WEST SUSSEX COUNTY COUNCIL CONSULTATION

TO:	<u>Arun</u> District Council <u>FAO:</u> Michael Eastham
FROM:	<u>WSCC</u> - Highways Authority: Tim Townsend
DATE:	27 March 2020
LOCATION:	Land to the south of Ford Lane and east of North End Road <u>Yapton BN18 0DS</u>
SUBJECT:	<u>Y/19/20/RES</u> Approval of reserved matters following outline consent Y/80/16/OUT for 4.5ha of residential development comprising of 3.4ha of land for the erection of 100 No. dwellings (up to 30 (30%) affordable housing) together with 1.1ha of land set aside for public open space & strategic landscaping & 2.2ha of public open space & green corridors with vehicular access from Ford Lane & pedestrian/cycle access only from North End Road. This application may affect the setting of listed buildings, affects the character & appearance of the Church Lane, Yapton Conservation Area & affects a Public Right of Way. Further information received.
DATE OF SITE VISIT:	<u>n/a</u> for purposes of this RES application (visited at outline stage)

PROPOSED DEVELOPMENT PLAN

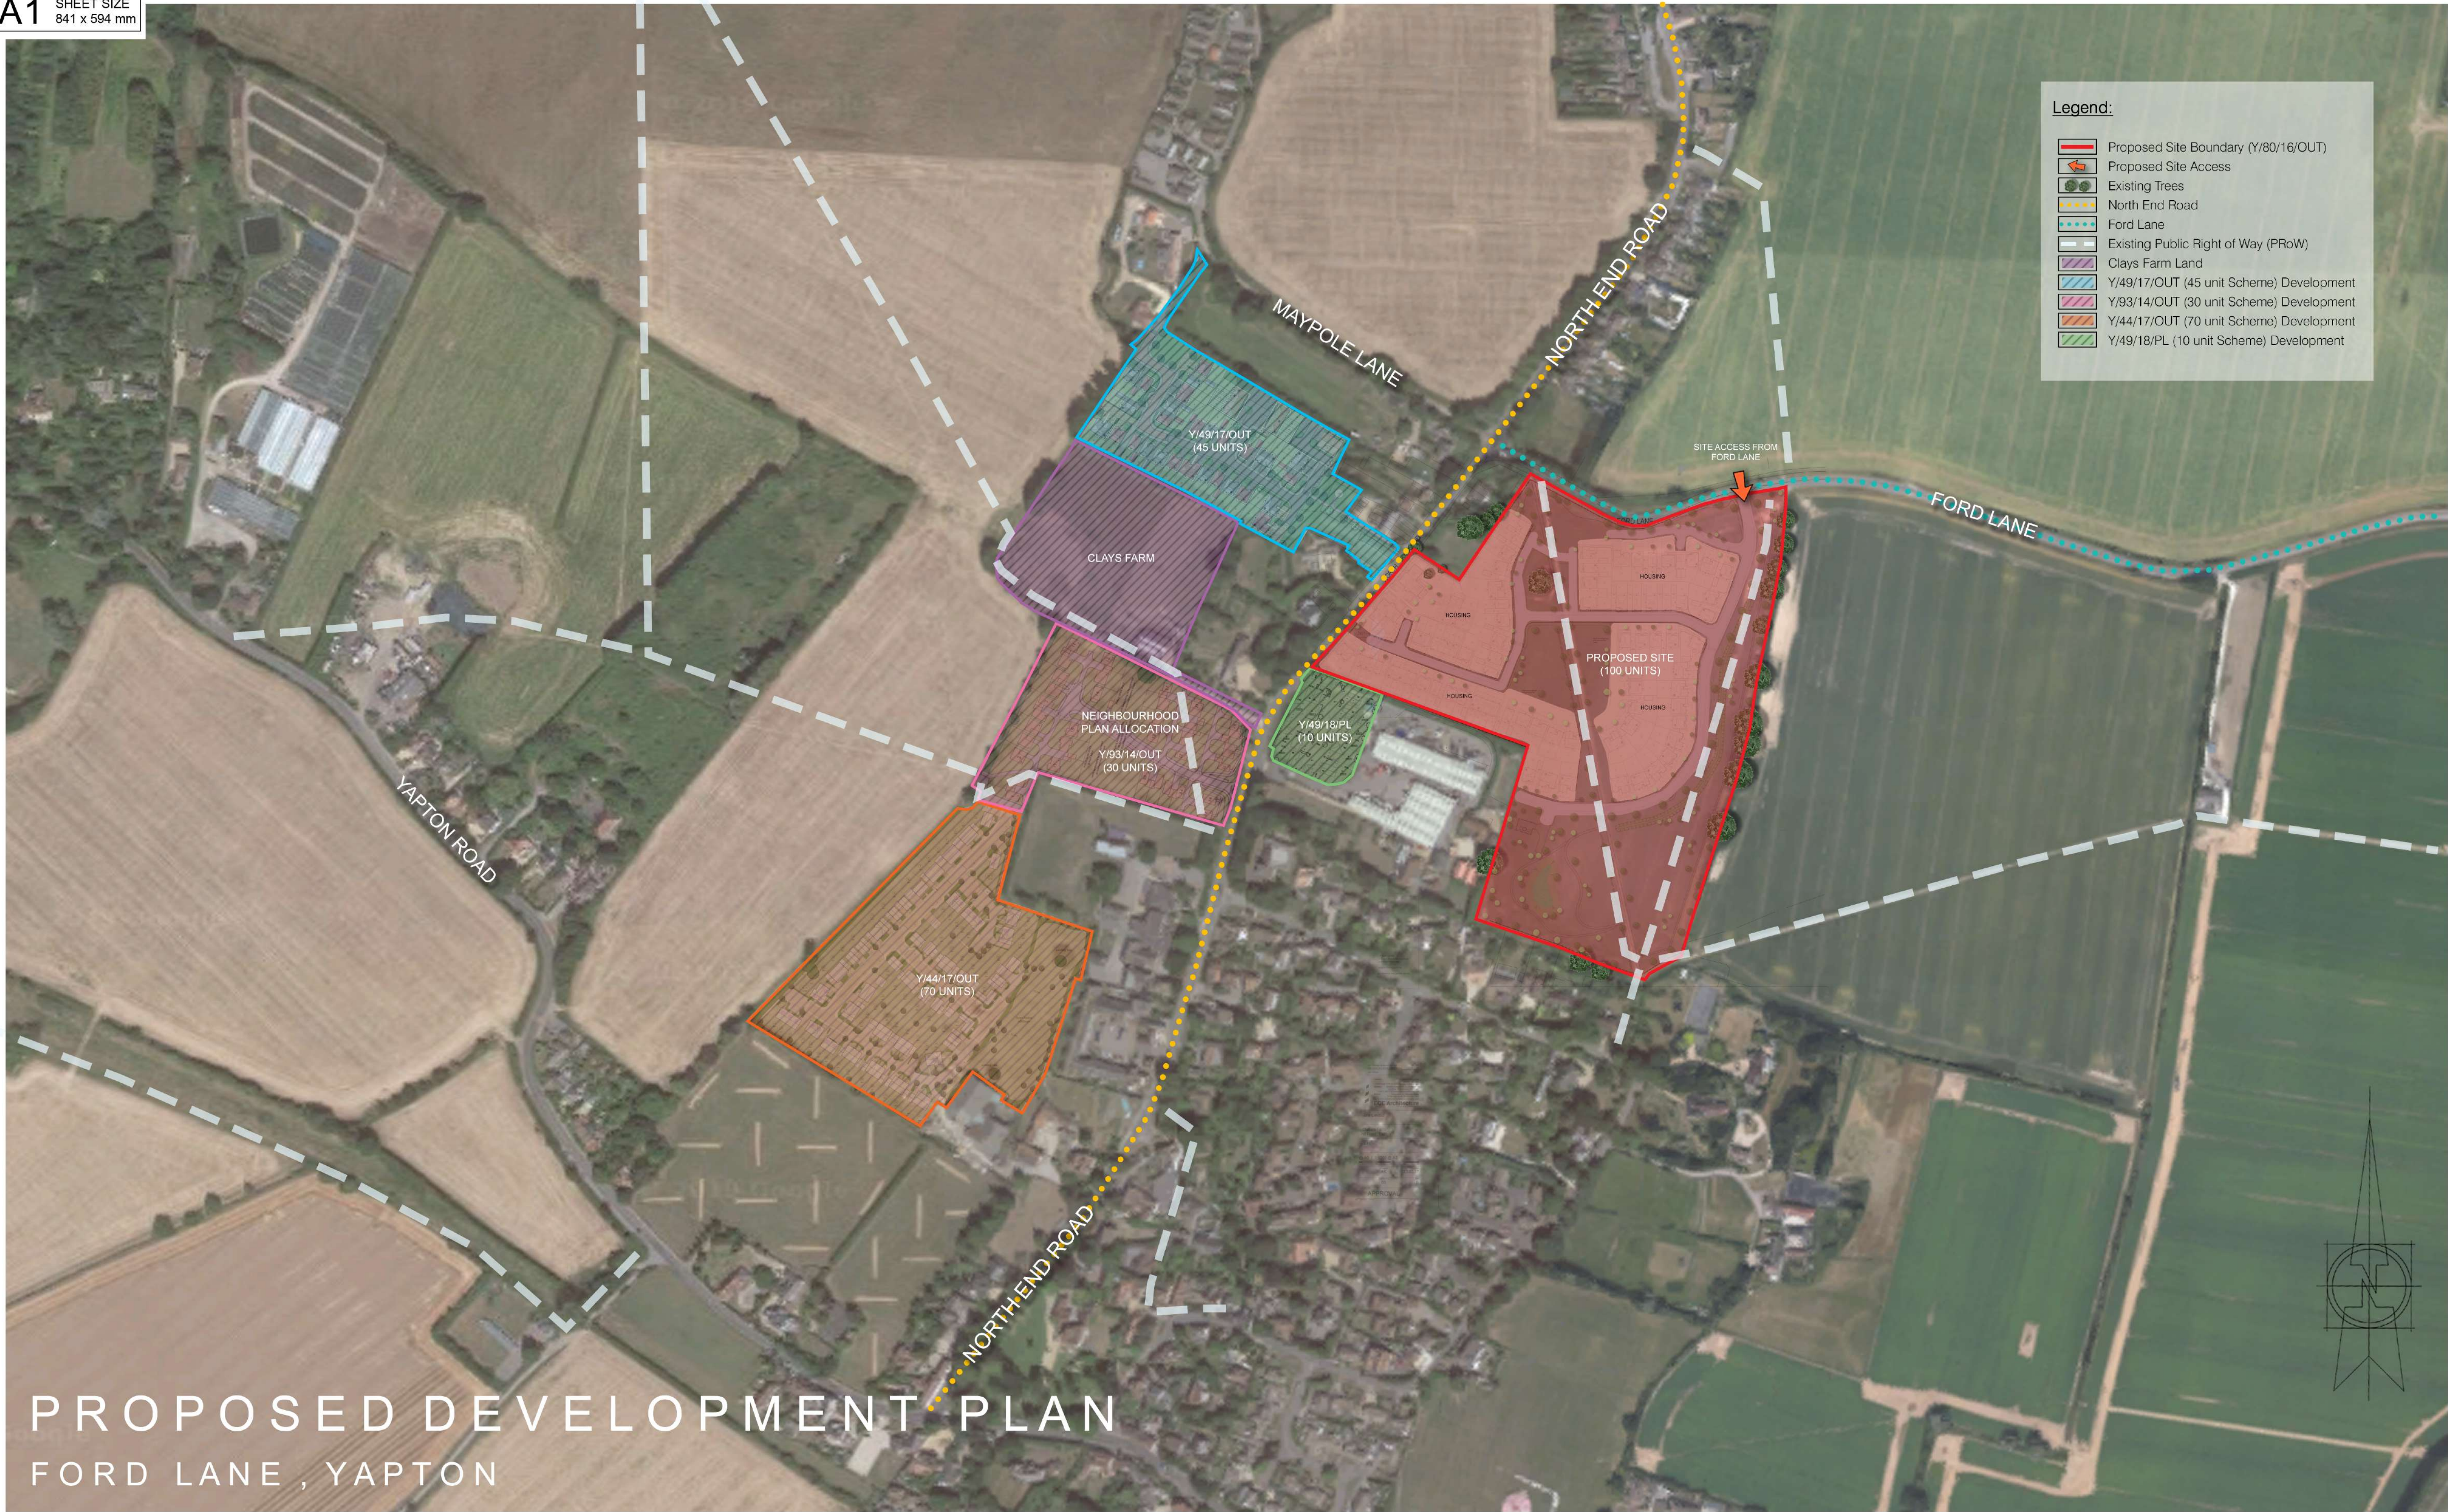
- 1. Internal access roads** – The first section of access road taken from Ford Lane up to plot 9 appears to measure 5.5m wide. Turning westwards, the access road appears to continue at a width of 5.5m up to plot 93. Beyond this, the access road appears to measure 4.8m wide. This is also true for the section of road serving plots 1-5 and 24-33. No access road should measure less than 4.8m wide as this can lead to difficulties for emergency and refuse vehicles (although in-line with Manual for Streets guidance, accesses can - for short distances only - be narrower). In the case of the layout as submitted, the sections serving plots 6, 7, 15-18, 36-45 and 54-58 have access 'roads' in the form of shared surfaces measuring between 4.1-4.8m wide. However, these and all the internal access roads have been 'tracked' for refuse and emergency vehicles and plans appear to demonstrate that such vehicles can reach all properties.

With regard to the design of the roads and access ways, footways are shown in specific places alongside either one side or both sides of the main access roads. In-line with advice in Manual for Streets, the internal roads where footways are proposed should ideally have footways provided on both sides as otherwise this could give a mixed-message to users. Also in places, desire-lines for walking trips appear to have been omitted which again could lead to users getting a mixed-message or simply walking where they wouldn't normally. As such, it is recommended that pedestrian provision alongside access roads be re-visited throughout the scheme – particularly the section serving plots 1-5 and the section south and west of plot 93 (so the western portion of the site). The shared driveway/accesses serving plots 6, 7, 15-18, 36-45 and 54-58 are specifically shown as shared surfaces without footways and subject to adequate spaces being available to turn vehicles and cater for visitors parking, these areas are largely acceptable (but see comments below about parking).

Finally, the applicant should demonstrate how traffic speeds would be controlled within the estate layout and why the chosen visibility splays shown are acceptable. Particular attention should be given to the access road running along the eastern side of the scheme.

Three formal Public Rights of Way (PRoW) - Public Footpaths in this instance - run through the site – namely 357, 358 and 359. The first two provide connections between Ford Lane through the site whereas No. 359 meets 358 at the south-eastern corner of the site and then (continuing as 357) towards Church Lane.

At the outline planning application stage, the CHA recommended that as part of any RES/DOC application that any PRoW running through the site be considered to provide for shared foot and cycle use. This has not been shown as 357 appears to measure 2.0m (it should measure a minimum of 3.0m wide for shared-use) but surfaced, whereas both 358 and 359 are not shown measuring more than 1.5m wide and without surfacing. Since the outline consent, the County Council has been looking at ways to improve access by non-motorised users across the County. This extends to other non-motorised users too and it has been mentioned that access by other users such as equestrians is of interest in the area. Bridleway status for these paths would legally permit those on foot, cycle and horse to use the paths, albeit recognising that the paths would need to be upgraded, including connections in-and-out of the site.

With regard to other paths within the site, a recreational area appears to be shown in the south-western corner of the site. This too should be looked at with a view to providing shared-use paths for a choice of users – those on-foot and cycle at the very least. Also, a further path running NE-SW across the central green/play area would also provide a path on a desire-line for pedestrians and should, as such, be considered.
